Your Ref: OWPC18087
Our Ref: LU/81/18/HH 23-03-2018
Please ask for:
Amber Willard

Single storey rear extension & new vehicle access.

31 North Ham Road Littlehampton

PROPOSED GROUND FLOOR PLAN

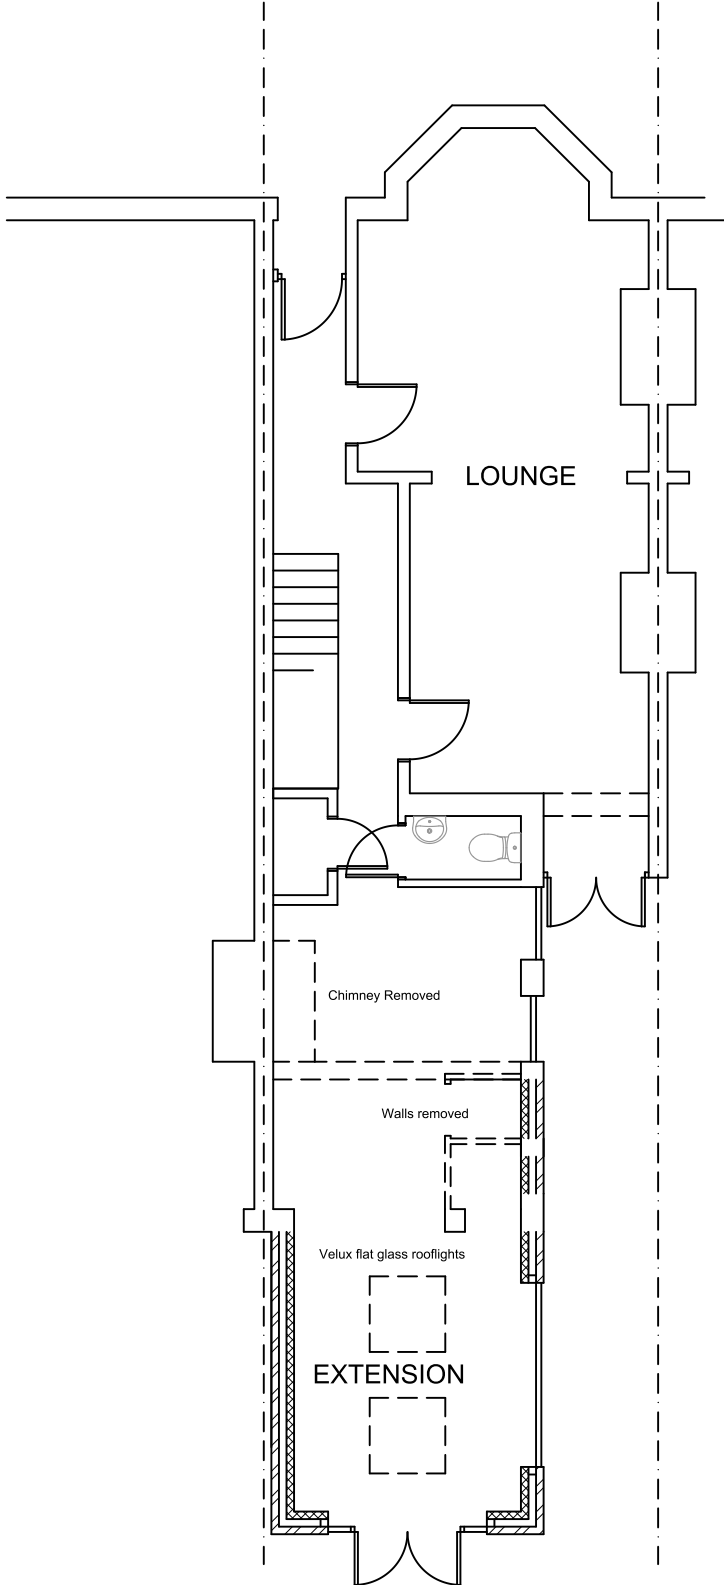
We would object to the provision of New Vehicle Access as this will mean the removal of the Flint Wall outside this property.

Flint Walls in Littlehampton are an intrinsic part of our built Heritage and this has been recognised by a recent visit and inspection of our built heritage by Martin Small BA(Hons) BPI DipCM MRTTP, Principal Adviser, Historic Environment Planning, South East Planning Group, Historic England.

In North Ham Road, the section from No 23 to No 37 is the last remaining fully intact stretch of front flint walls to the properties, in North Ham Road. Further destruction of these flint walls will see yet another needless attack on the Heritage of our Town.
